From: Simon Davis
Sent: 20 March 2020 16:36
To: Lauren Wiltshire [REDACTED]
Cc: Daniel Vick <Daniel.Vick@arun.gov.uk>
Subject: RE: FP-171-18-PL

I agree that the decision was made in accordance with the plan which you attached to the email (17094-PL-2-07 RevD - Boundary Materials). This specifies that the boundary between the new houses and properties on Wellers Close should be a 1.8m high fence. However, the plan does not specify that a new fence is to be erected and if the existing fence is already 1.8m then there would be no breach of the planning permission. If however the existing fence is lower, then yes we would expect to see either a new fence erected or the existing one replaced to a height of 1.8m. If you consider that the boundary would then be too low, you could consider raising the fence or planting shrubs on your side to provide extra screening. You don't need planning permission for a boundary height of 2m but beyond that, permission would be required. However, no permission is required for planting. You may wish to approach the developer to ask if they will raise the fence.

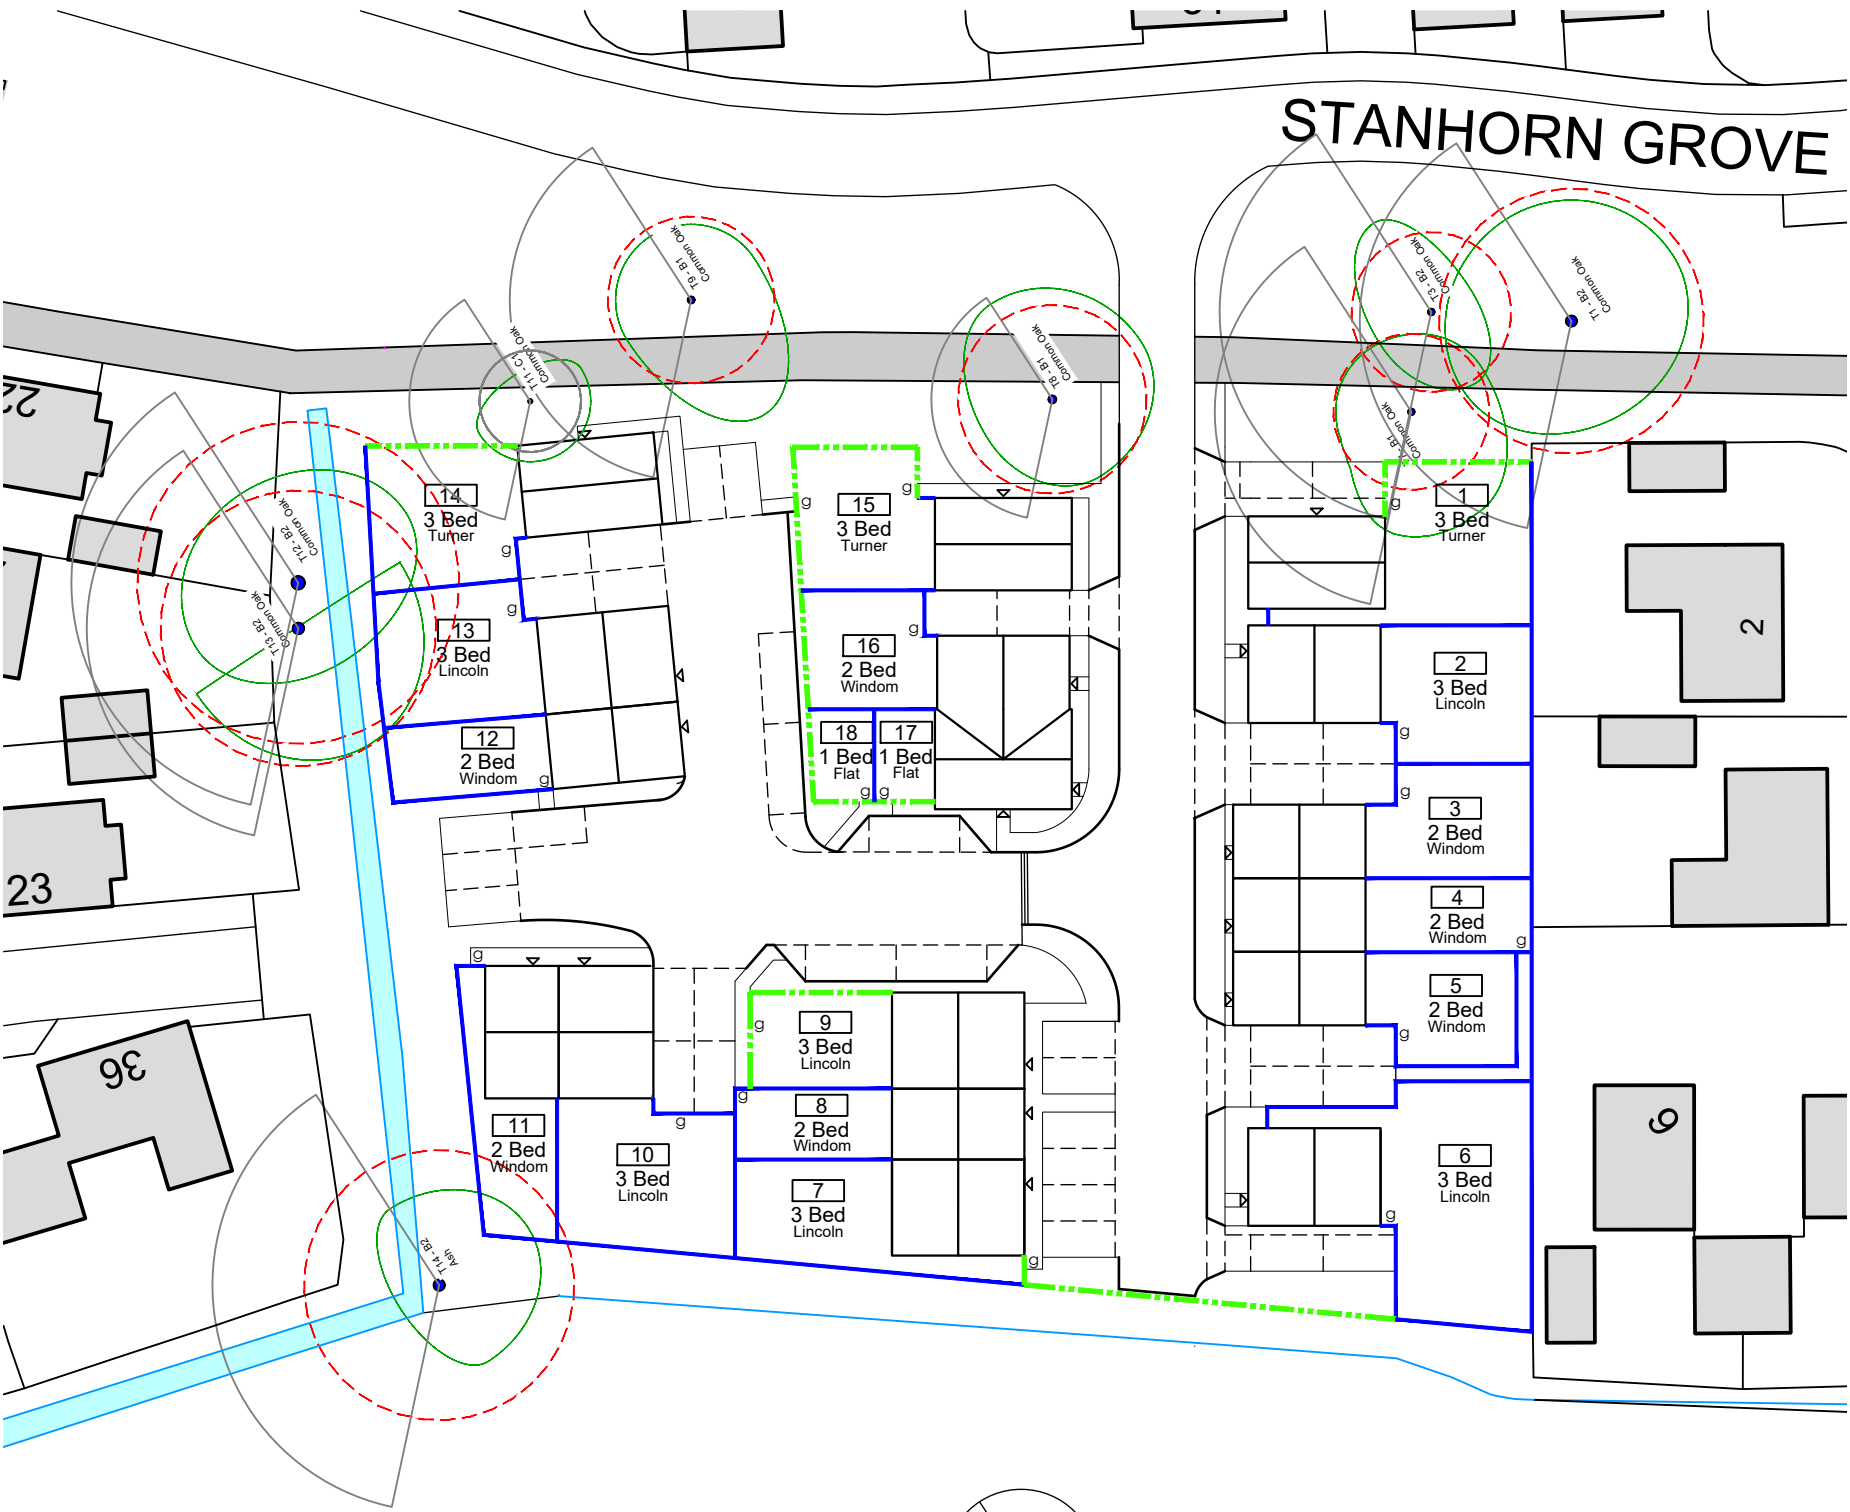
As I understand it from Mr Cooke, you are placing a new 1.8m high fence immediately adjacent to the existing boundary fence which is lower on Mr Cooke's side. Whilst I disagree that the approx. 0.2m high difference is going to be an eyesore to Mr Cooke and other residents, I do consider this to represent poor design and I note that existing residents do have a right to maintain their fences and that if you put another fence behind, this will make this very difficult, perhaps impossible without the new fence being first removed. This is likely to create conflict going forwards between residents on both sides. The plan that was approved as part of the planning application (PL-2-07 Rev D) simply states that the eastern boundary will be a 1.8m high timber fence. It does not show a new boundary up against the existing and if it had of done, then we would have raised concerns at the time. Therefore, I would request that you give consideration instead to abandoning the proposal to erect a new fence and instead replace the existing so that it is 1.8m high.

Dear Mr Davis follow on from your note below I would confirm the boundary between the my property and the development next door now does not meet with the planning consent given as the boundary is no longer 1.8 metres high, I have been told that a secondary boundary fence will be erected (this is yet to be confirmed and would be a total eye sore on my side). I would also question the gradient from the new properties as there seems to be a drain off ditch between the pathway and my fence leaving my property susceptible to excess water runoff and the issue of damage to my boundary fence caused by an expedited wood rotting. I also note at some points along the boundary to top soil is already above the gravel boards.

We are installing a fence on our boundary as per the approved boundary plan 1.8m close board.
